17 April 2023

Re: LVL sizing – 589 Rainey Dr. Spring Lake, NC

Jenkins Consulting Engineers, PA

FLOOR PLAN 589 RAINEY DRIVE

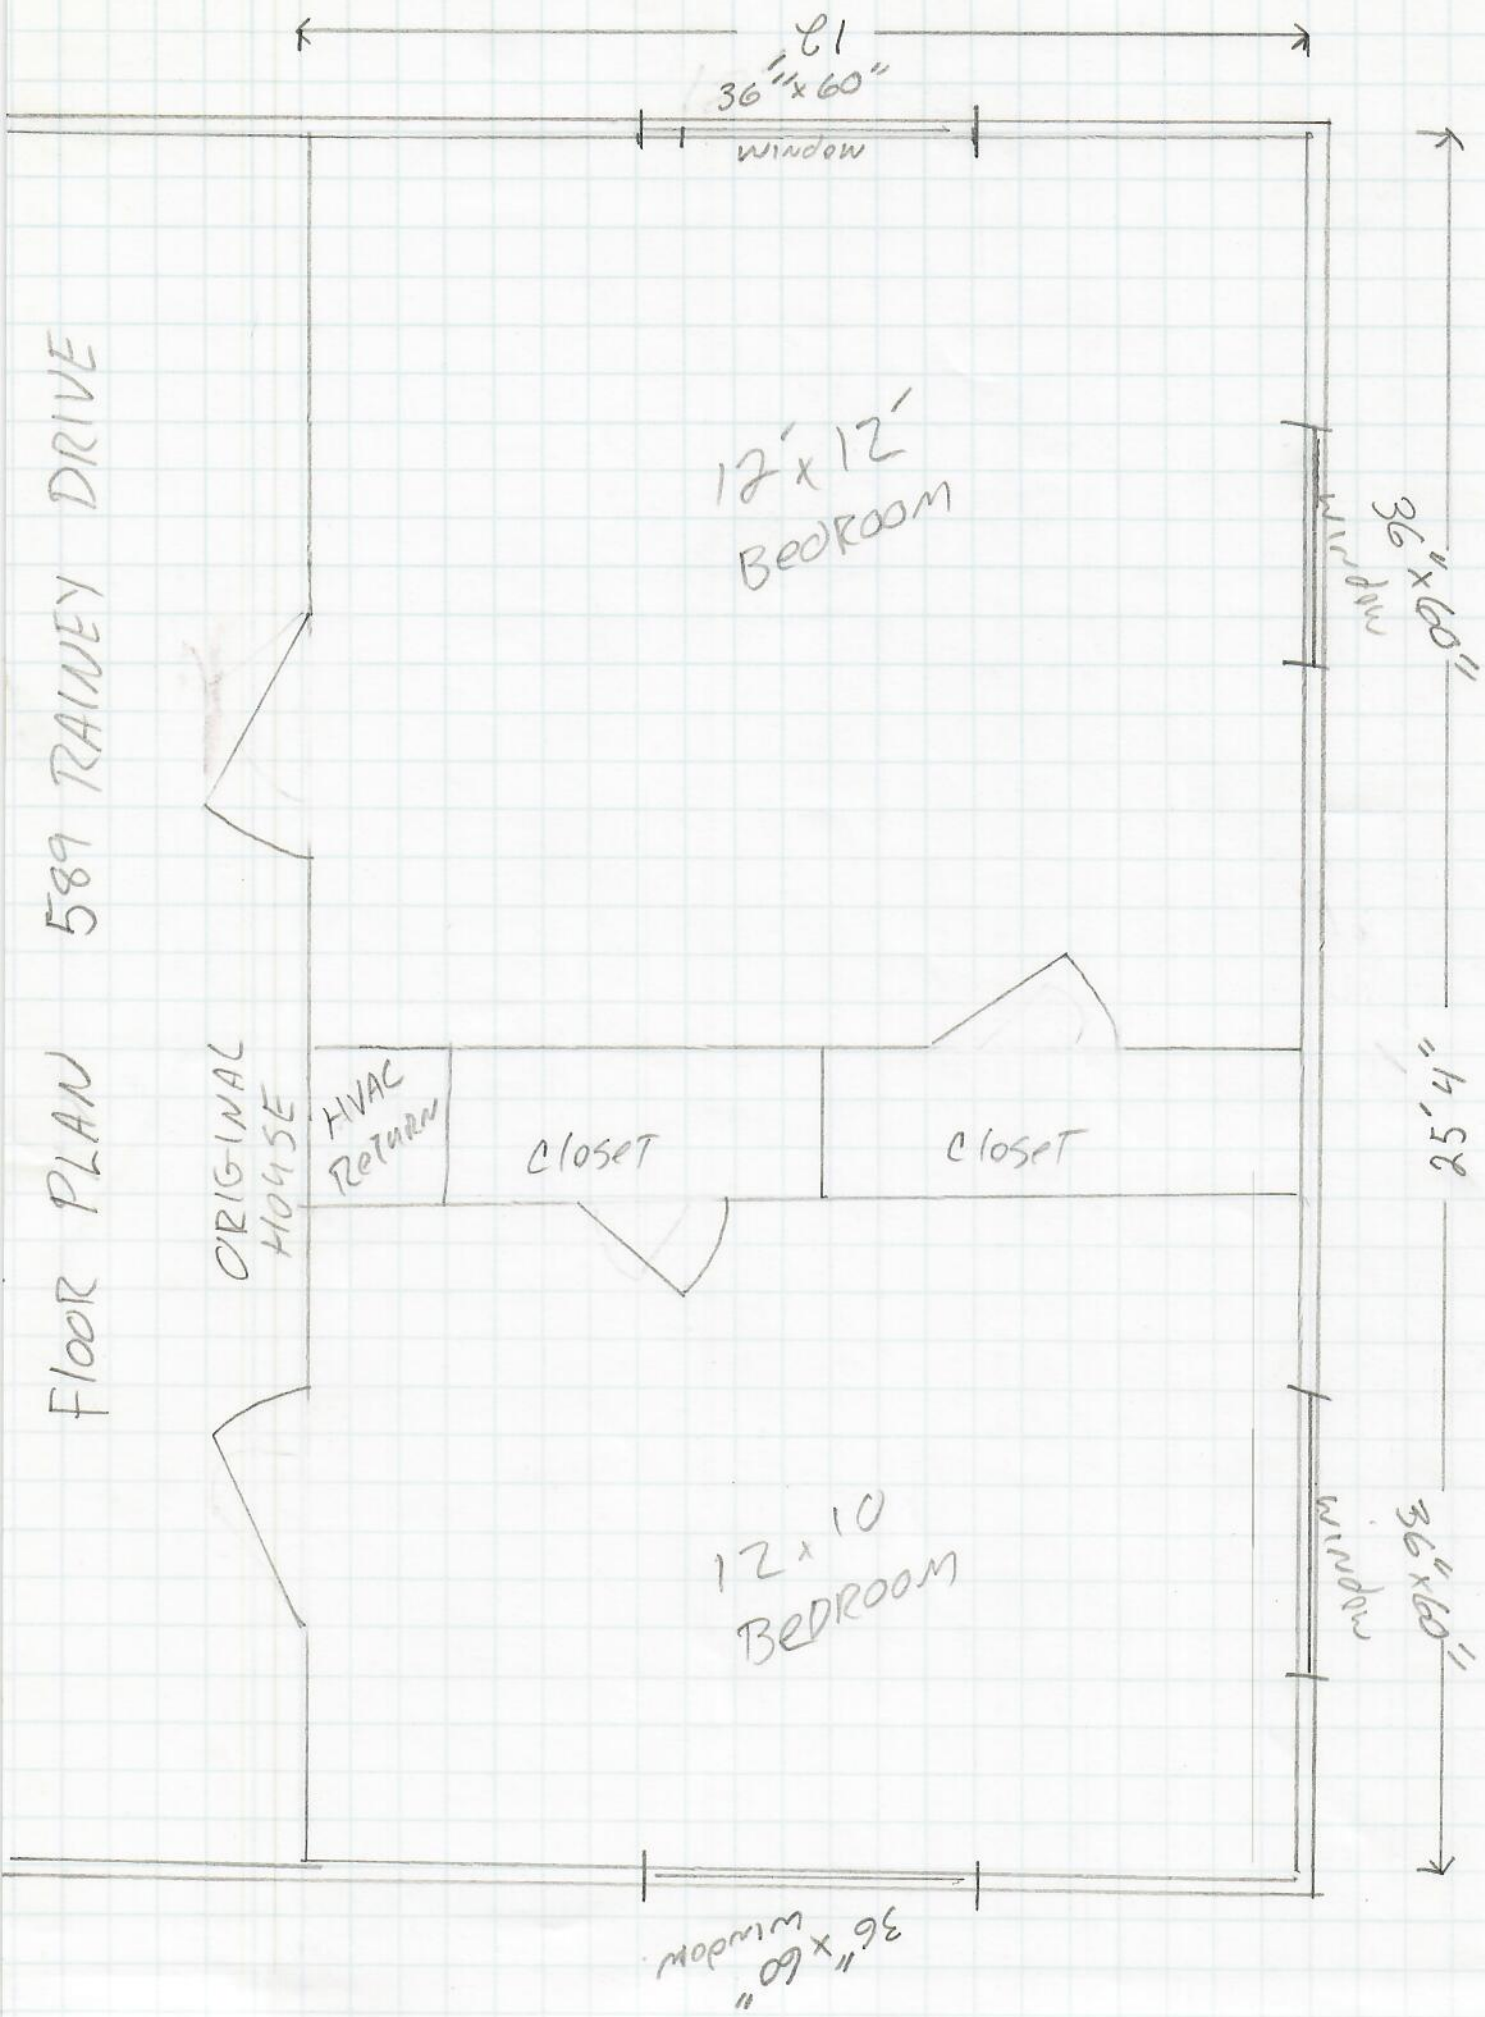
Jenkins Consulting Engineers (JCE) has reviewed two LVLs installed at the subject location. There is one located at the top of a previous exterior wall, and allows for the openings to be made in the load-bearing exterior wall. This LVL shall be a double 9-1/4" LVL, installed with a minimum of 3.5" bearing on both ends. Contractor shall verify that both bearing ends are constructed over a pier with concrete footing. The second LVL is installed under the ridge beam. This LVL is not meant to replace any of the structural members, as all original members are still intact. The house is aged, and the LVL was installed to help correct a sag due to settling. It is recommended to install a pier under the bearing end (towards the interior) to transfer the newly imposed load.
